Our ref: HA/2022/123981/02-L01
Your ref: BN/11/22/OUT
Date: 28 November 2022

RESPONSE TO EA COMMENTS - OUTLINE APPLICATION WITH ALL MATTERS RESERVED (EXCEPT FOR THE A29 REALIGNMENT) FOR THE DEMOLITION OF EXISTING STRUCTURES AND MIXED USE DEVELOPMENT TO PROVIDE RESIDENTIAL DWELLINGS (USE CLASS C3), CARE HOME/SENIOR LIVING ACCOMMODATION (USE CLASS E/F2/SUI GENERIS), A PRIMARY SCHOOL PLUS OPEN SPACE, LANDSCAPING, DRAINAGE AND ALL OTHER ASSOCIATED ANCILLARY WORKS; AND REALIGNMENT OF THE A29 AND EARLY CONNECTION TO EXISTING A29 INCLUDING CONSTRUCTION OF A NEW ROAD CARRIAGEWAY, JUNCTIONS AND ASSOCIATED INFRASTRUCTURE. THIS APPLICATION ALSO LIES WITHIN THE PARISH OF ALDINGBOURNE, AFFECTS THE SETTING OF LISTED BUILDINGS, AFFECTS THE CHARACTER & APPEARANCE OF THE EASTERGATE CHURCH LANE CONSERVATION AREA AND AFFECTS A PUBLIC RIGHT OF WAY. THIS APPLICATION IS THE SUBJECT OF AN ENVIRONMENTAL STATEMENT. BARNHAM, EASTERGATE, WESTERGATE BEW PARCEL SC1 BARNHAM

In the absence of an acceptable flood risk assessment (FRA) we **object** to this application.

Appendix A – General Arrangement for 200m Multi-Span Option

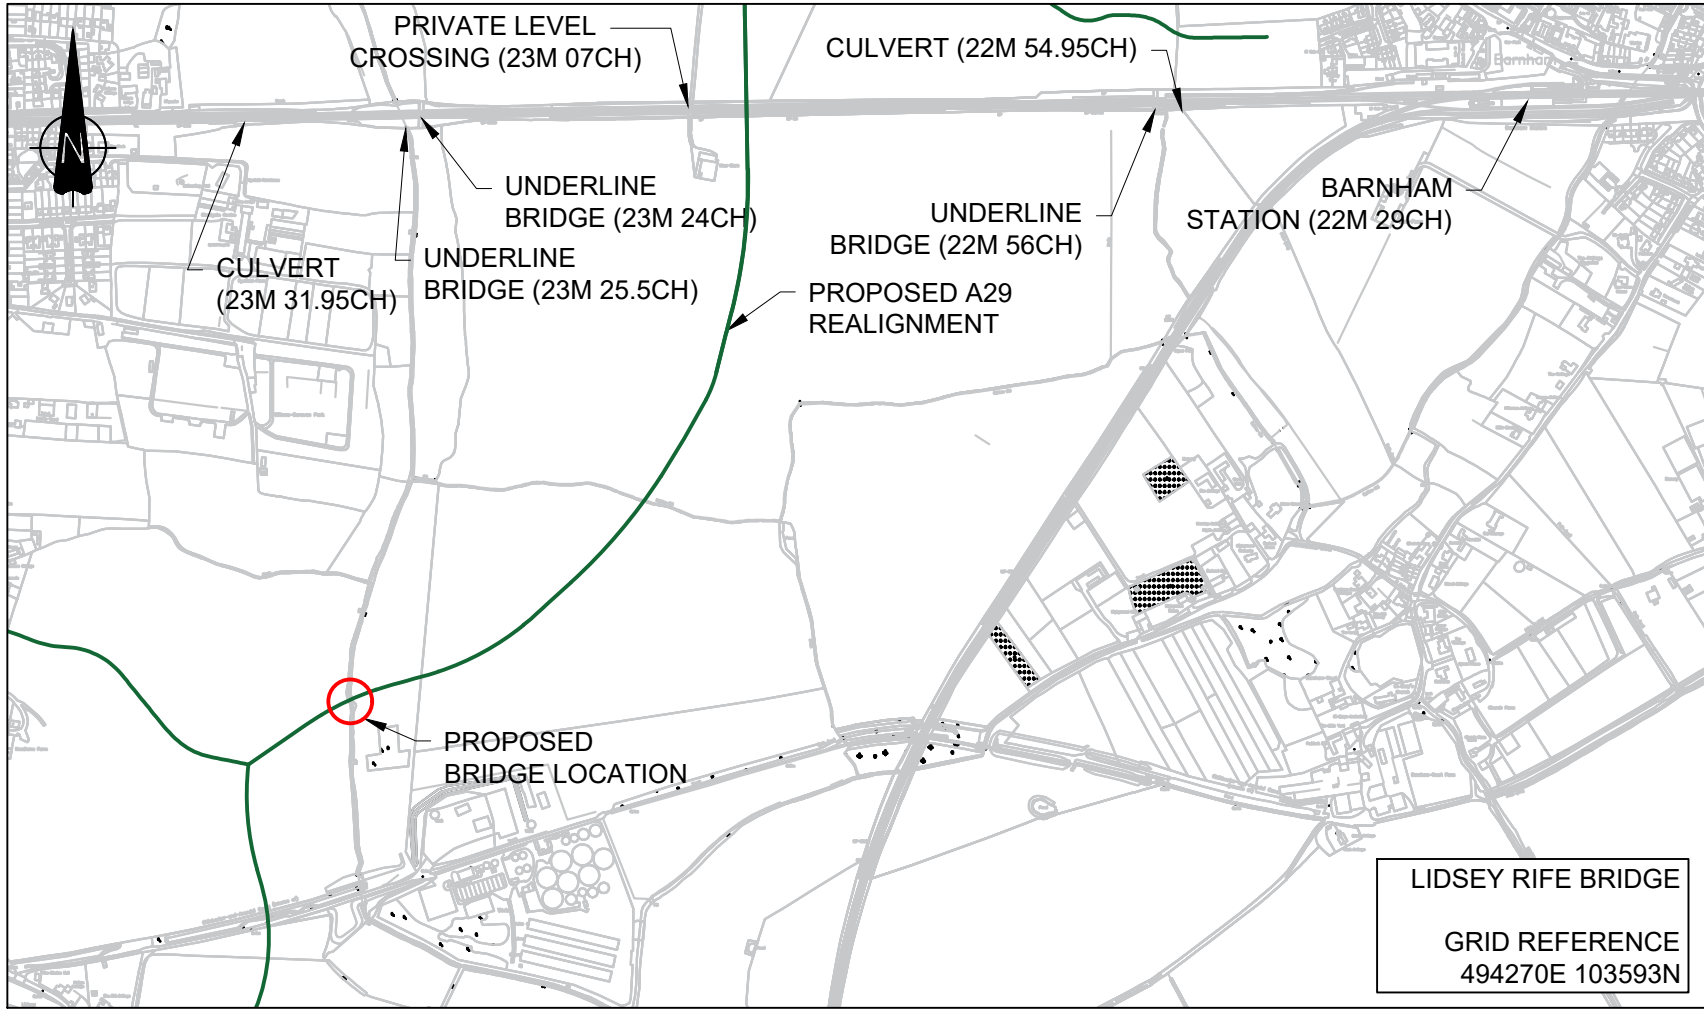
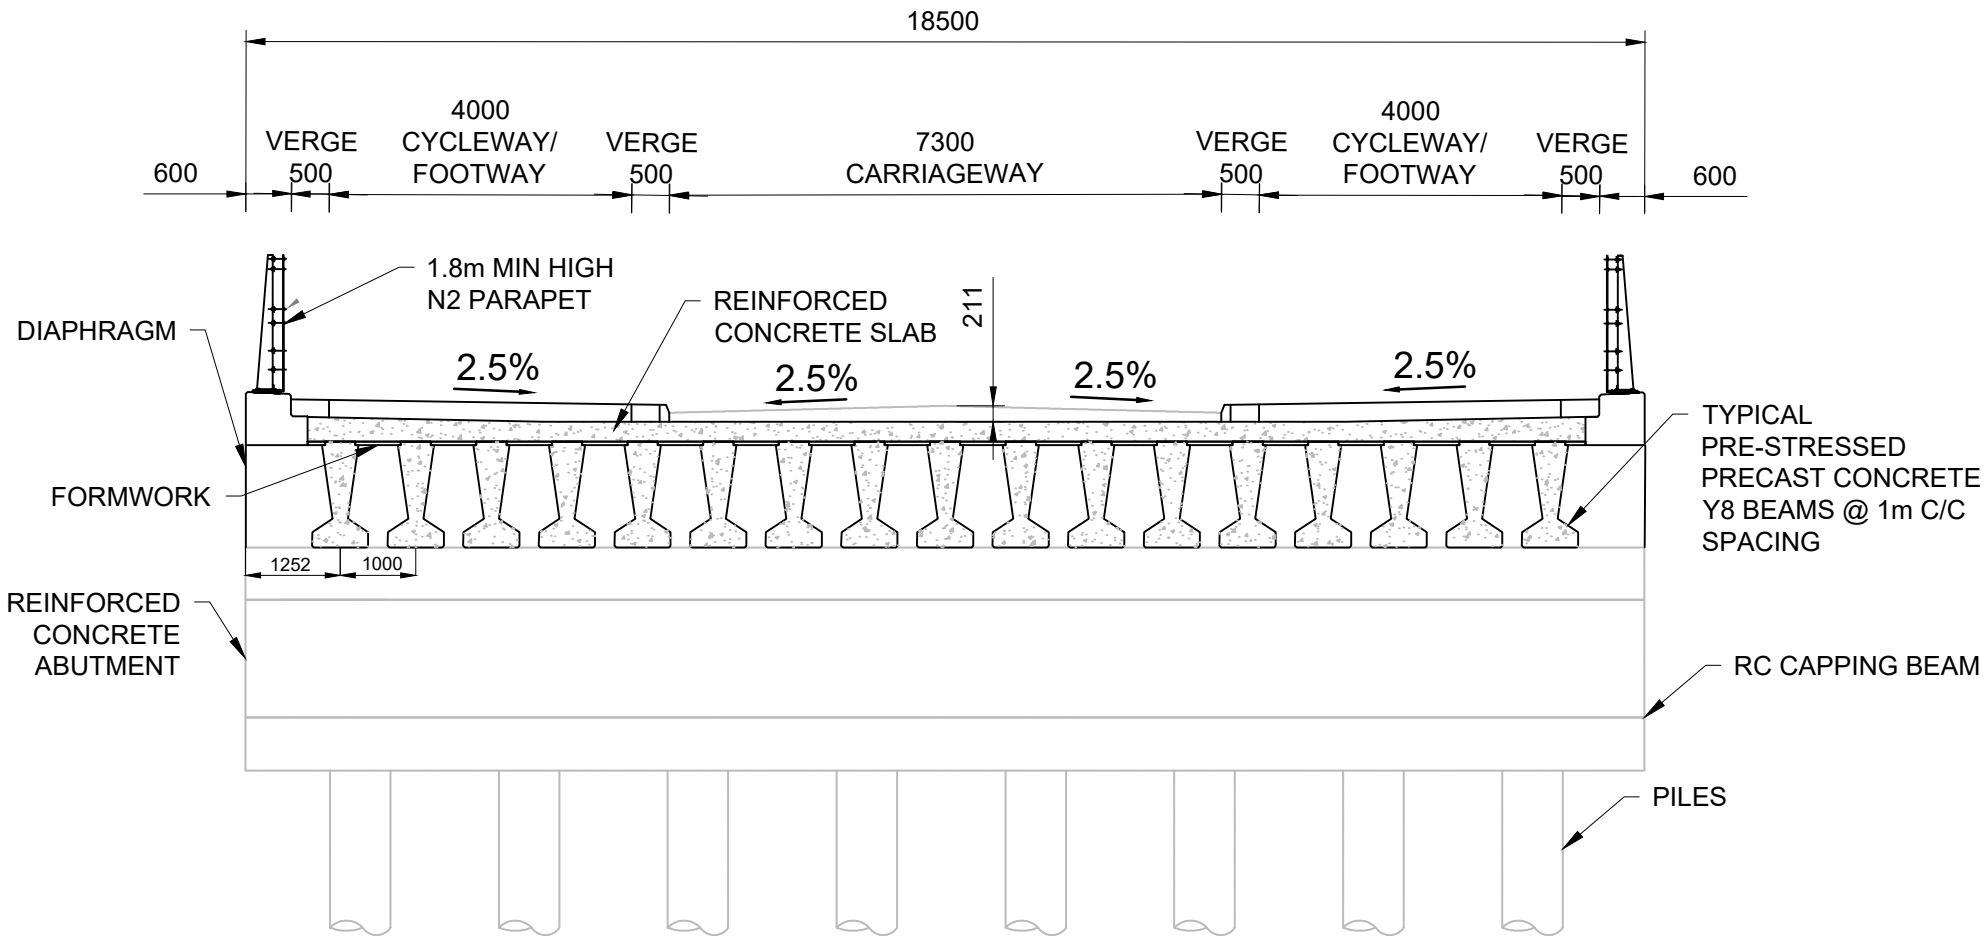
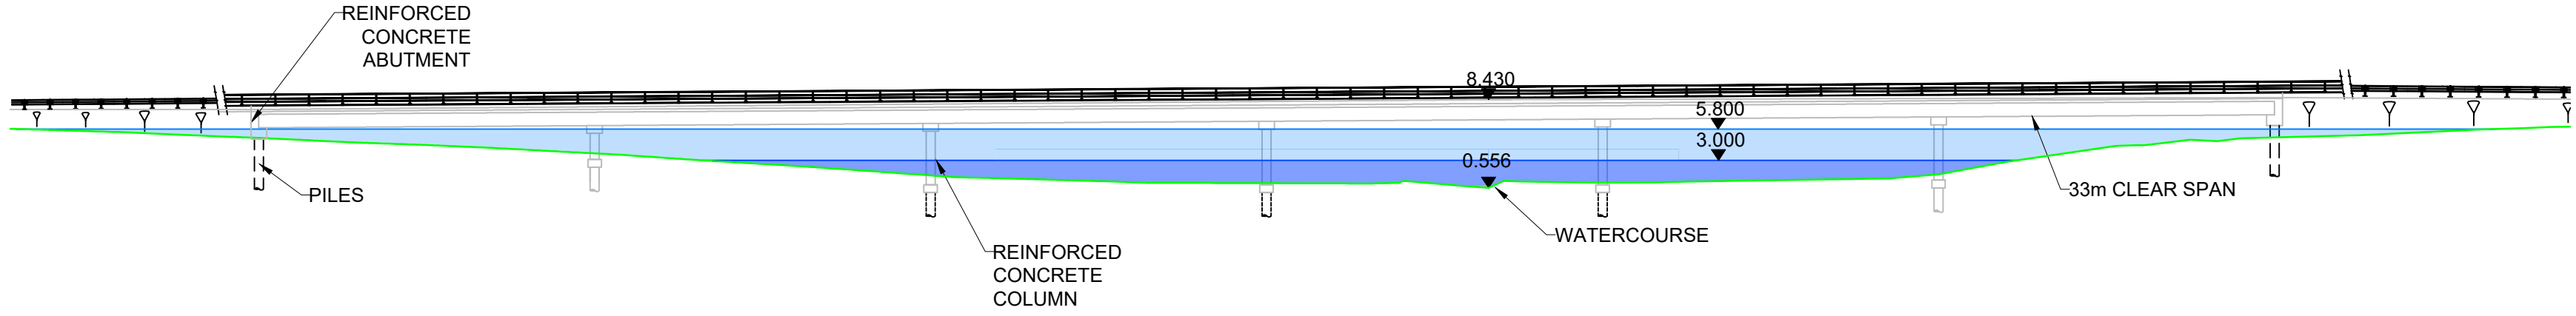
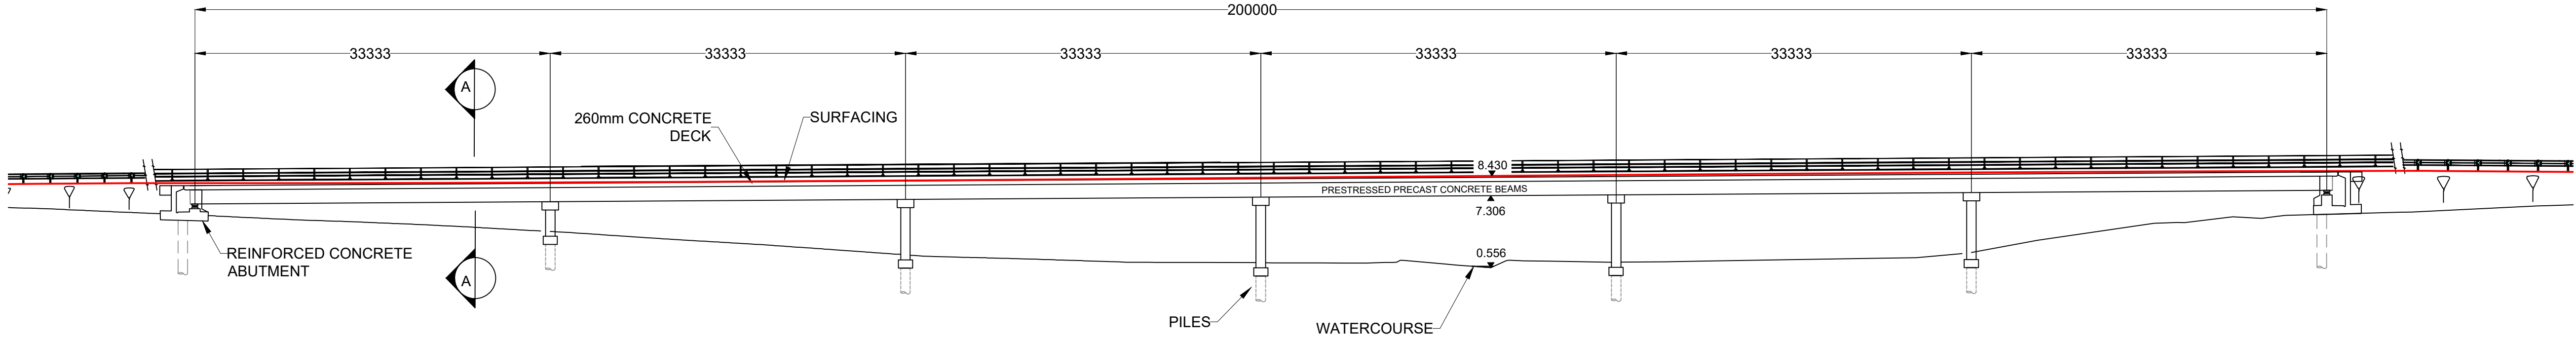
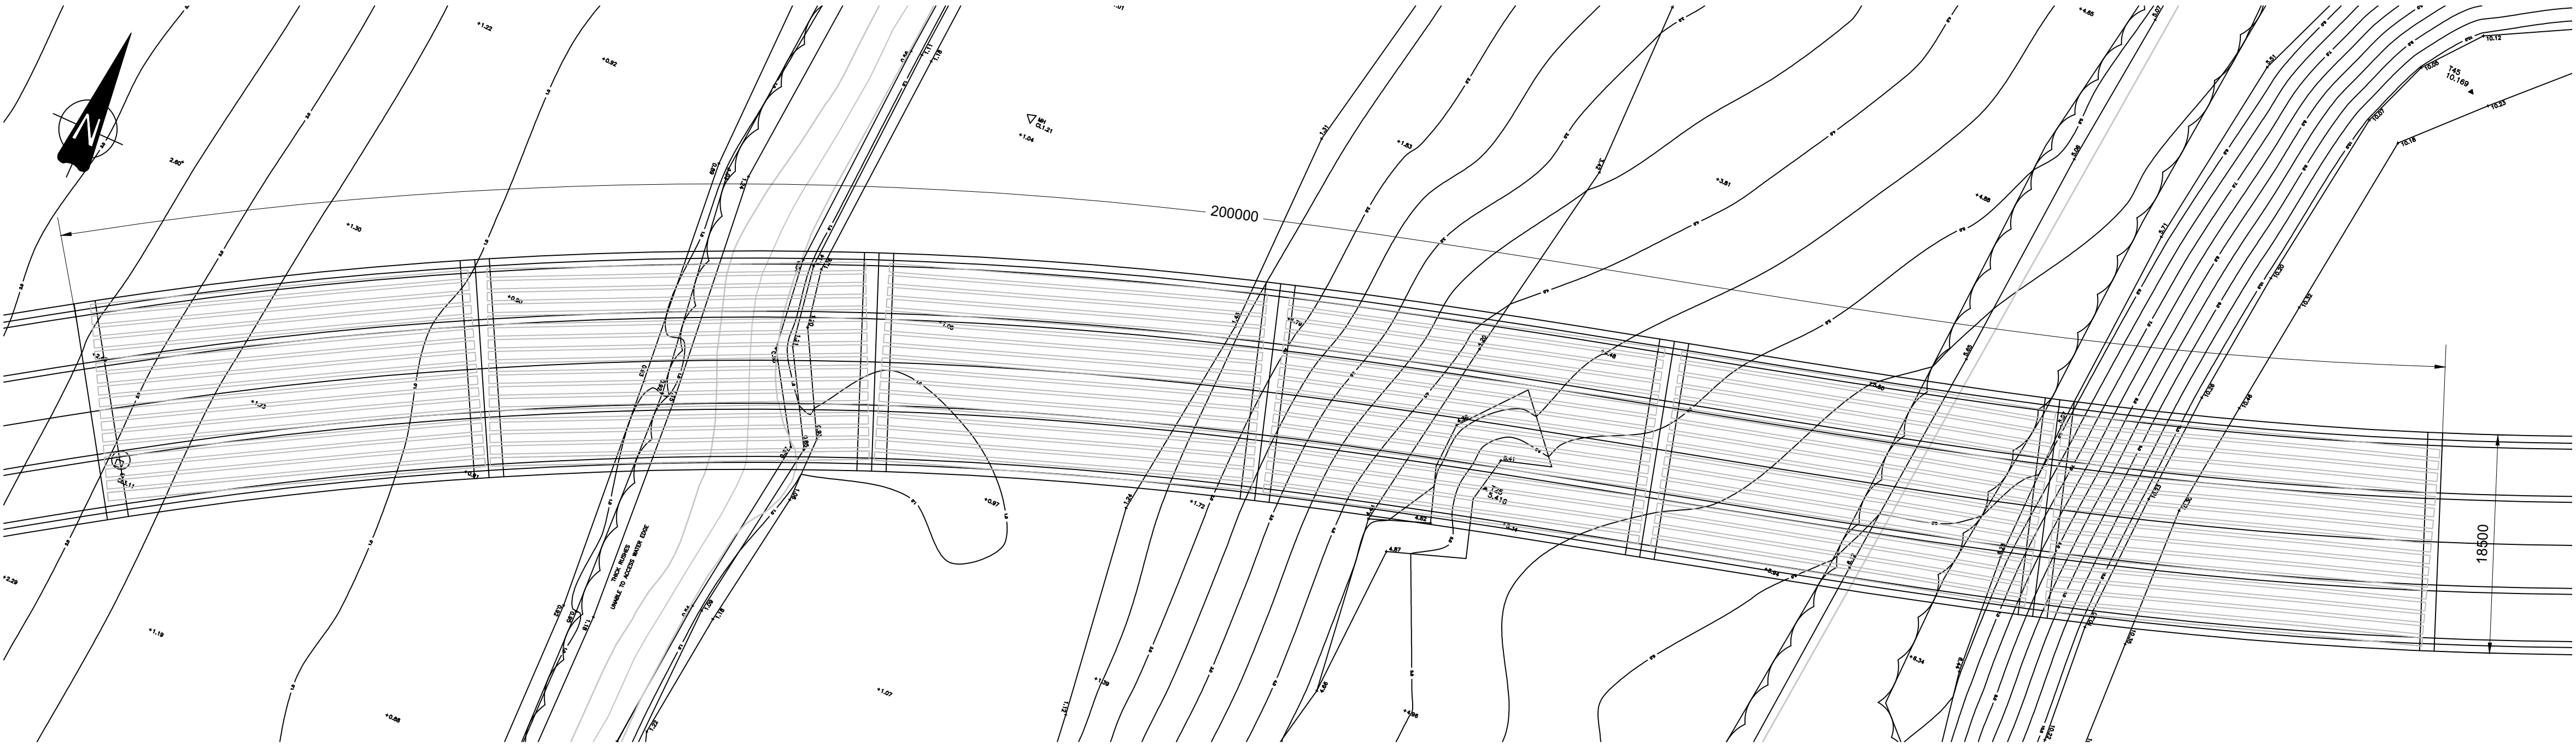
We would again highlight our preference for the 200m multi-span option from a flood risk perspective but would note that this would also require flood plain compensation for the bridge piers. This would need to be evidenced and we would again expect the applicant to review the risk.
